Harnett County
420 McKinney Pkwy
LILLINGTON, NC 27546
Phone:
Fax:

SUBJECT: **SFD2506-0002**
SINGLE FAMILY DWELLING

Here are the results of all Inspections located at **21 GREEN LINKS DR:**

Inspection Type: MONO SLAB
Scheduled Date/Time: 7/22/2025
Completed Date/Time: 7/22/2025
Inspector: Ricardo D Honrada
Result: DISAPPROVED
Remarks: eTRAKiT Inspection Request
Notes: 7/16/2025 5:10 PM Glenwood Homes

MONOLITHIC SLAB FOUNDATION PLAN
ELEVATION 1

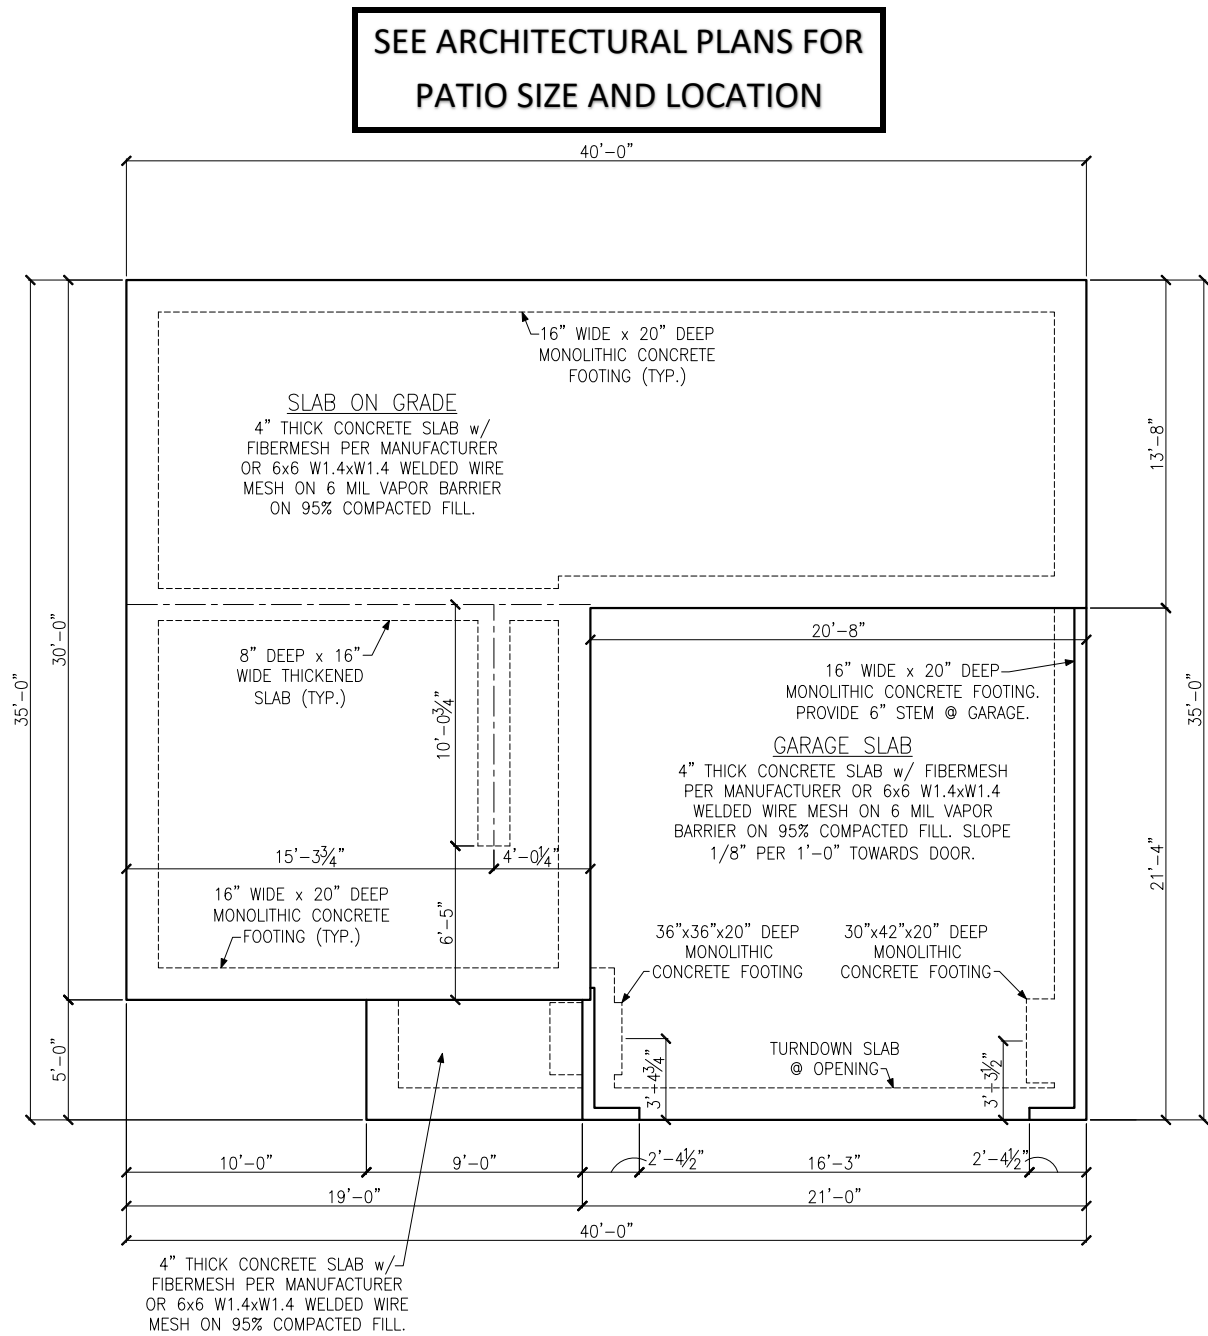
Wall footings in garage 20 inches deep as per plan
